Fire Marshal Division

Re: New Life Worship Center
7022 Elliott Bridge Rd.
Spring Lake, NC 28390

Application Numbers – BCOM1809-0005

New Life Worship Center
Modular Classroom - Childrens Church
(Emergency Evacuation Plan)

New Life Worship Center - for childrens church

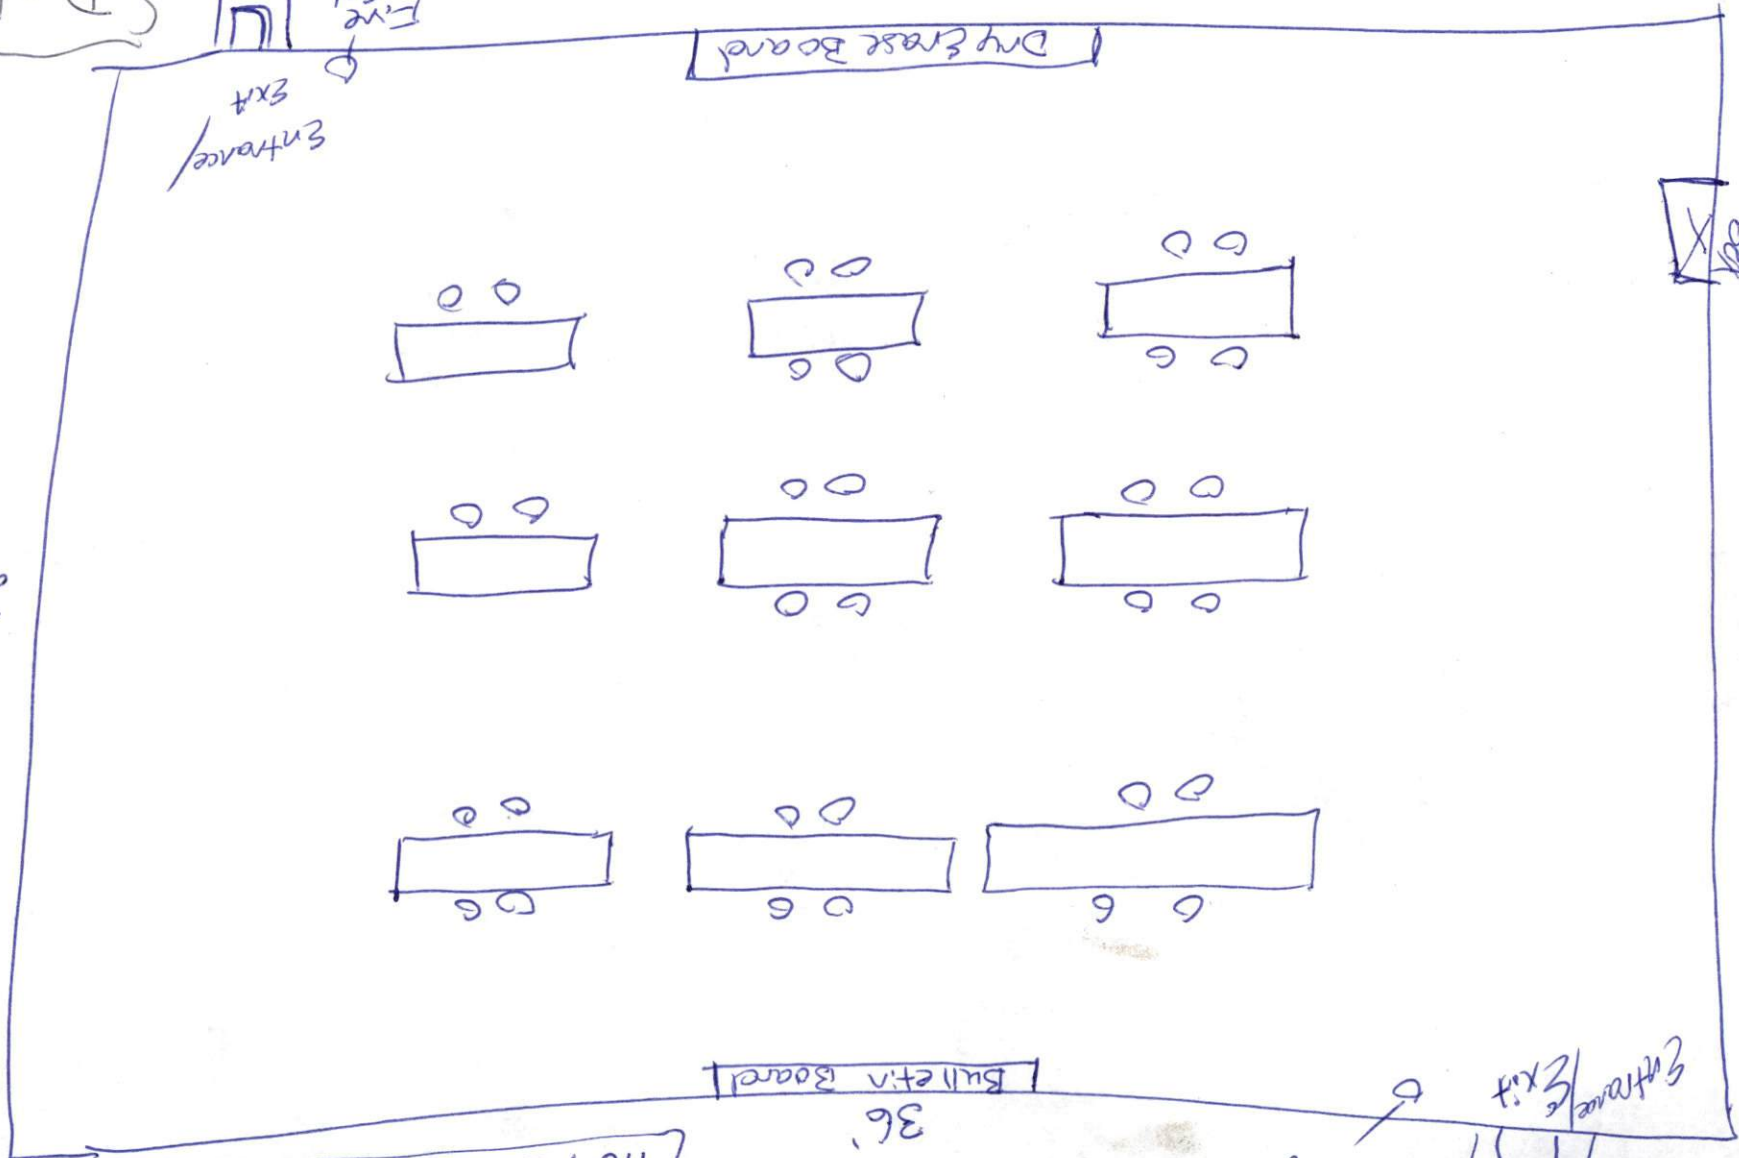
- **1003.2.11 Means of egress illumination.**
 - The means of egress, **including the exit discharge**, shall be illuminated at all times the building space served by the means of egress is occupied
 - The portion of the exterior exit discharge immediately adjacent to exit discharge doorways in buildings required to have two or more exits.

- **906.1 Fire Extinguishers**
 - Fire extinguishers shall be located as not to exceed 75' of travel distance to an extinguisher.
 - The fire extinguishers provided shall have a minimum rating of 2A10:BC and shall not be installed higher than 5 feet above the finished floor.

- **404.2 Fire Safety and Evacuation Plans**
 - An approved fire safety and evacuation plan shall be prepared, posted and maintained for Group E occupancies.
